UNSW Science and Engineering Building

Attachment A - Response to Submissions

Figure 2: SEB Ground Floor Store and Waste Holding Area

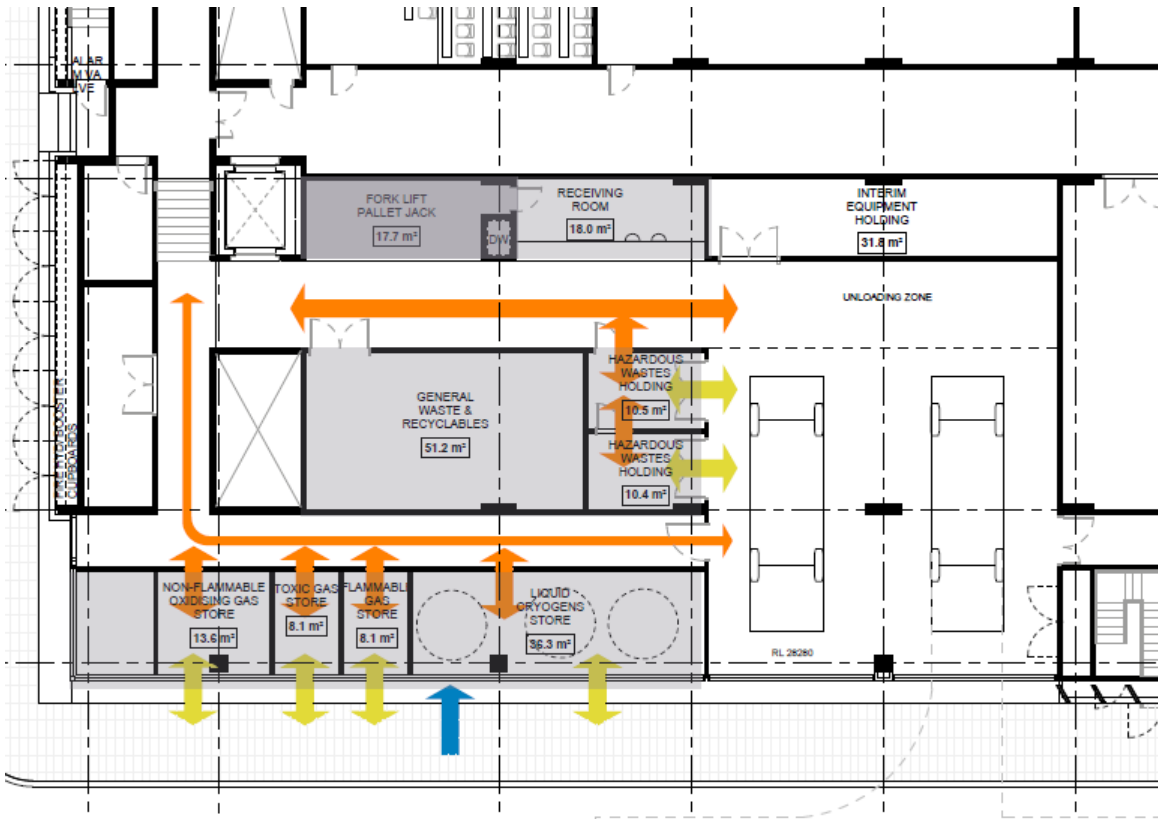
Hazard Waste Storage	
Section 3.6 "Hazardous Waste" of the EIS references the SEPP 33 Review report (Appendix D) and the Waste Management Plan (Appendix N). Figure 3-6 of the SEPP 33 Review report shows a different site layout (indicating storage locations for DG and hazardous waste) compared to Figure 2 of the Waste Management Plan. As such, please provide clarification on the site layout for the proposed development.	Core Engineering has updated their report to show the most recent location for the DG stores at Figure 3-1 (refer to Attachment B).
Figure 3-6 of the SEPP 33 Review report and Figure 2 of the Waste Management Plan shows that the flammable gases (including LPG) will be stored in an enclosed area. Please provide clarification if the design of this area will be in accordance with the relevant Australian Standards (AS 1596, in particular).	Core Engineering notes that SEPP 33 does not include safety protections in the analysis (with the exception of bunds when measuring storage locations to boundaries). Notwithstanding this, the SEPP 33 Review has been updated to reference the relevant Australian Standards (refer to Table 3-1). A copy of the updated SEPP 33 Review is provided at Attachment B.
